REFUSAL OF PERMISSION FOR DEVELOPMENT

Application Number: 2023/62/93162/W

ERECTION OF EXTENSIONS AND ALTERATIONS TO ONE DWELLING TO FORM 2 DWELLINGS, DEMOLITION OF EXISTING EXTERNAL STORE, WIDEN PARKING BAY, IMPROVE EXTERNAL STEPS AND ACCESS, EXTERNAL AND INTERNAL ALTERATIONS (LISTED BUILDING)

At: 57-59, CLIFF ROAD, HOLMFIRTH, HD9 1UY

Proposed Elevations

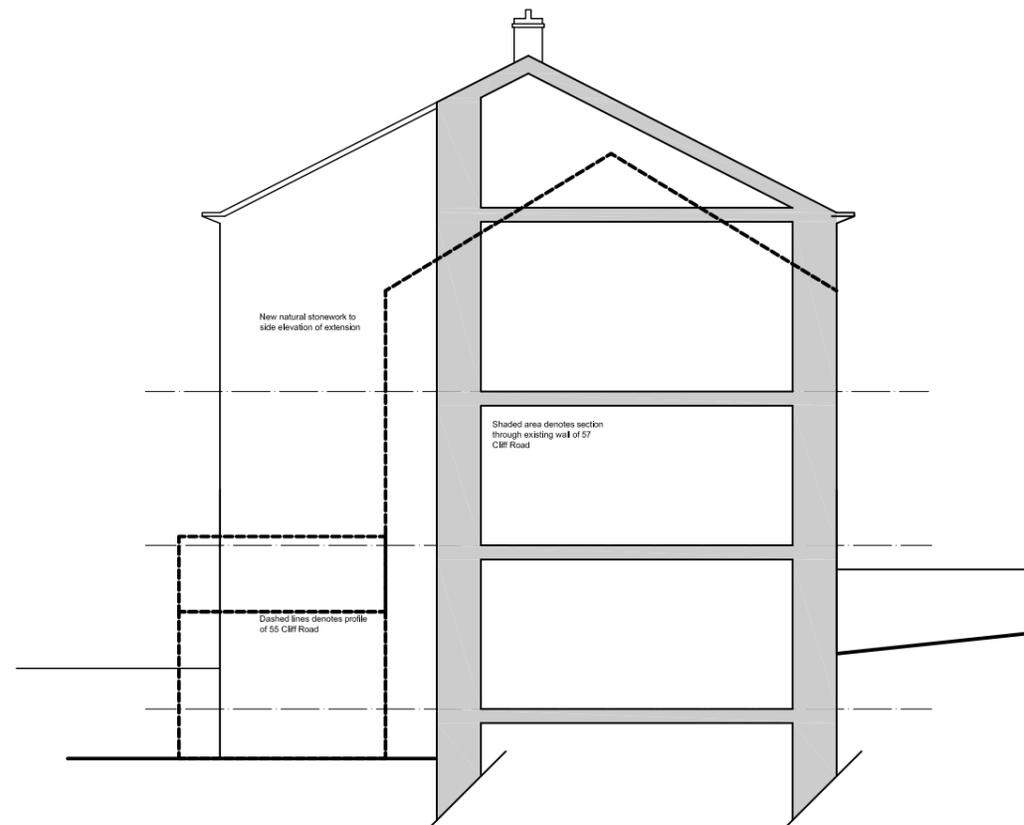
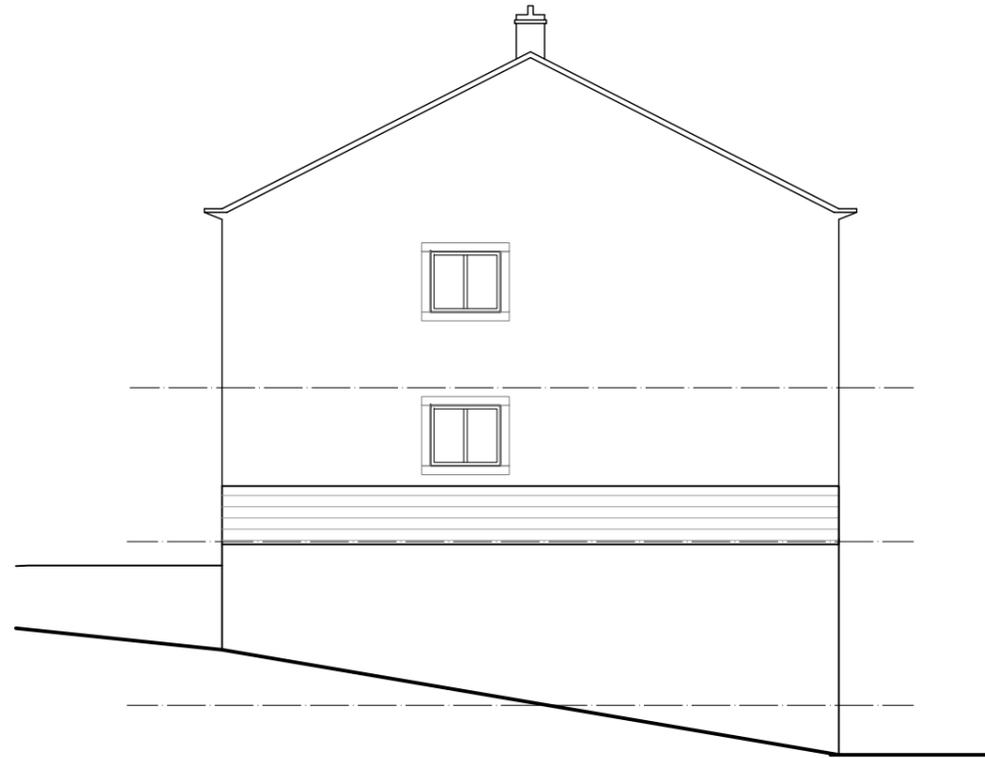
1. The proposed rear extension to No. 57-59 Cliff Road would have a detrimental impact on the visual amenity and heritage significance of the application site and surrounding area by adding a piecemeal addition to the rear elevation which would compromise the historic fabric of the building. This would be harmful to the setting of the listed building and wider visual amenity. This would also result in less than substantial harm to the significance of the listed building for which no public benefits to outweigh this harm, including justification, have been demonstrated. The development is contrary to Policy LP24 (a and c) and LP35 of the Kirklees Local Plan, Principle 2 of the Housebuilders Design Guide Supplementary Planning Document, Policies 1 and 2 of the Holme Valley Neighbourhood development Plan, Chapters 12 and 16 of the National Planning Policy Framework and the Council's duties under the Planning (Listed Buildings and Conservation Areas) Act 1990.
